From: Contact Centre (CRM) <contact@ribblevalley.gov.uk>
Sent: 08 June 2025 20:04
To: Planning
Subject: Planning Application Comments - 3/2025/0083 FS-Case-721345655

Planning Application Reference No.: 3/2025/0083

Address of Development: The Works Talbot House Main Street Gisburn BB7 4HD

**Title:** Proposed Plans and Elevations  
-New Build

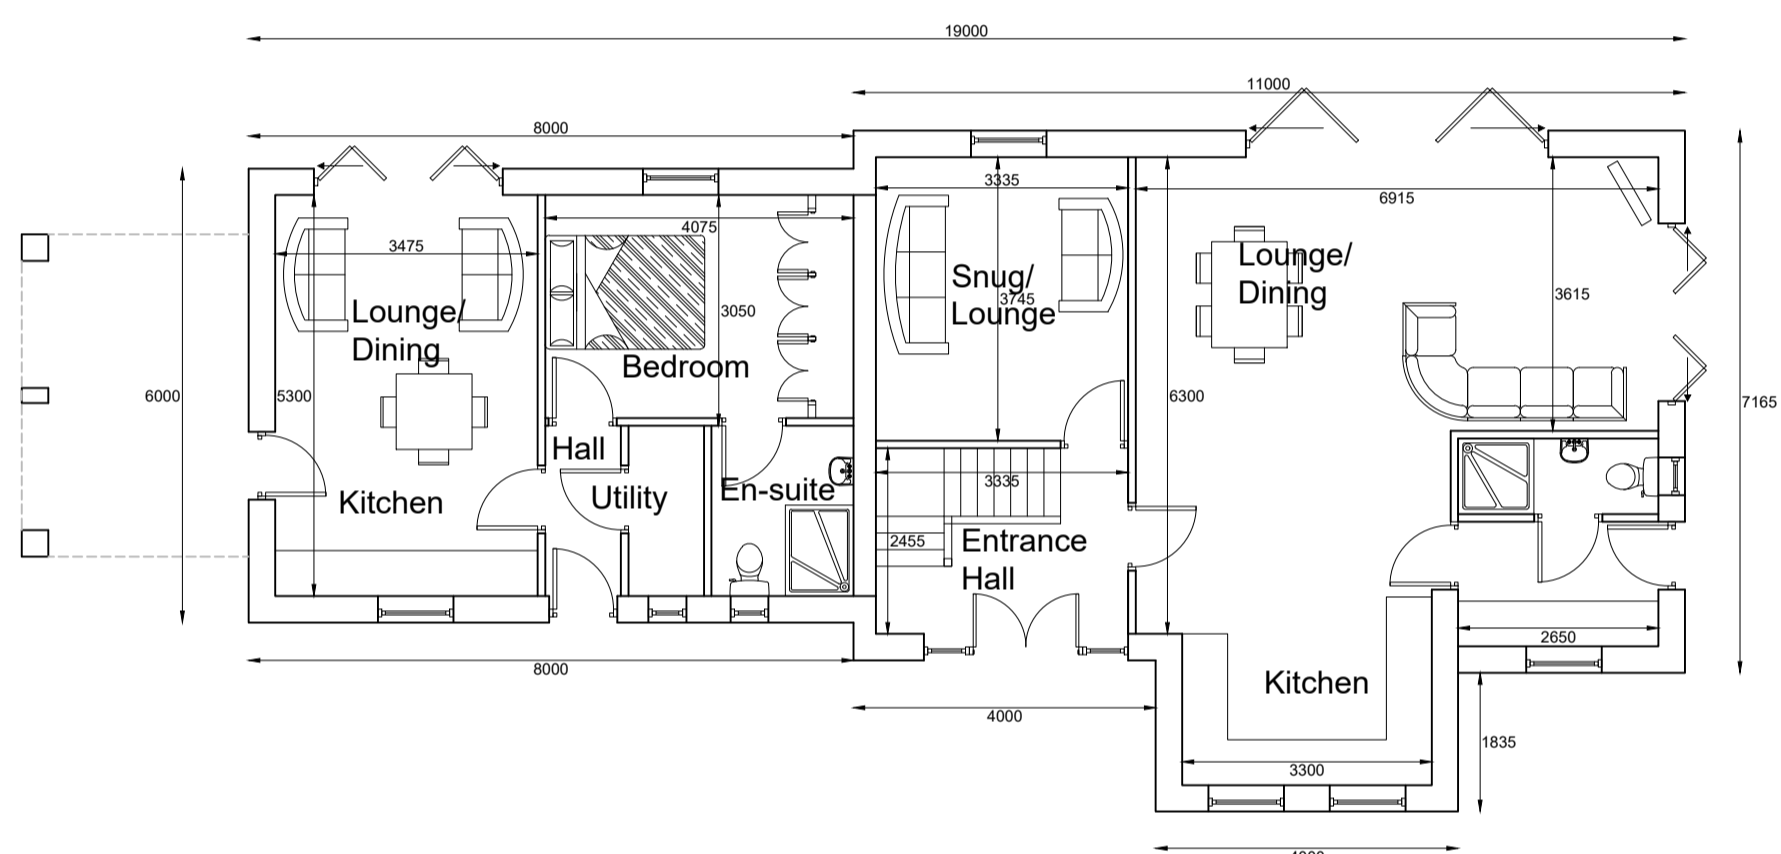
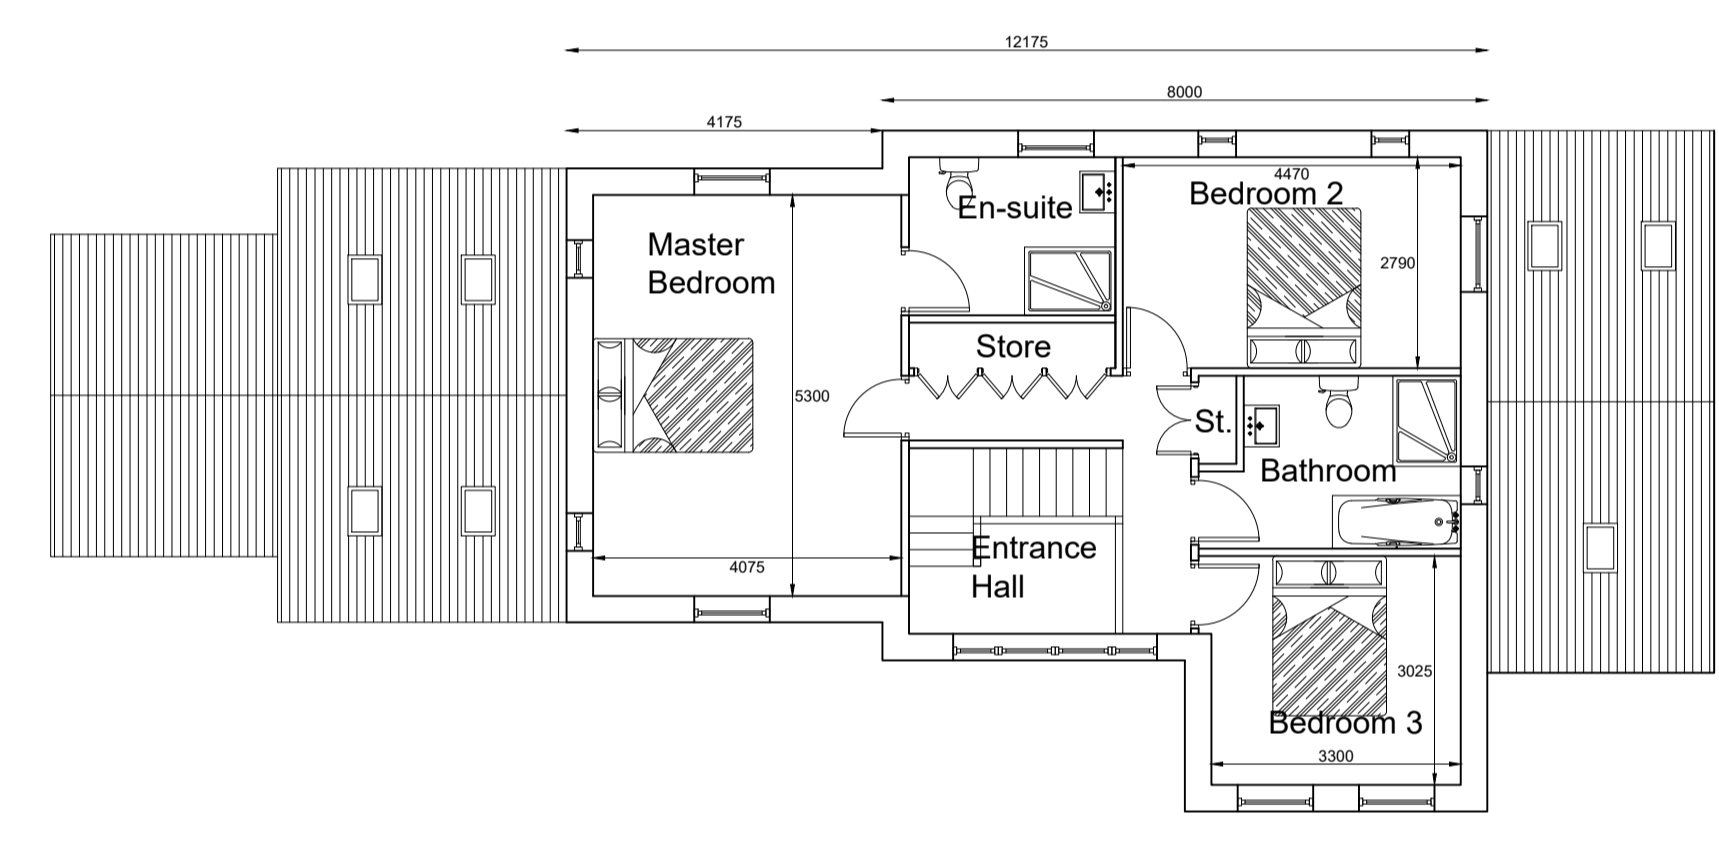
Comments: The proposed development would impact on the north facing view from multiple Main Street properties, given that the double storey aspect of the building would occupy the currently empty space with views to the Yorkshire Peaks. Changing the orientation/location of the building on the plot of land would improve this (for example using the car parking area to build on, or having the single storey element of the building on the east side). This wouldn't impact any residents, as the view is already restricted from the existing building. Traffic to and from the site (both during building and on completion with business and domestic vehicles) would increase significantly through the narrow underpass, which has poor visibility and is in a hazardous location with its proximity to the bus stop and pub.
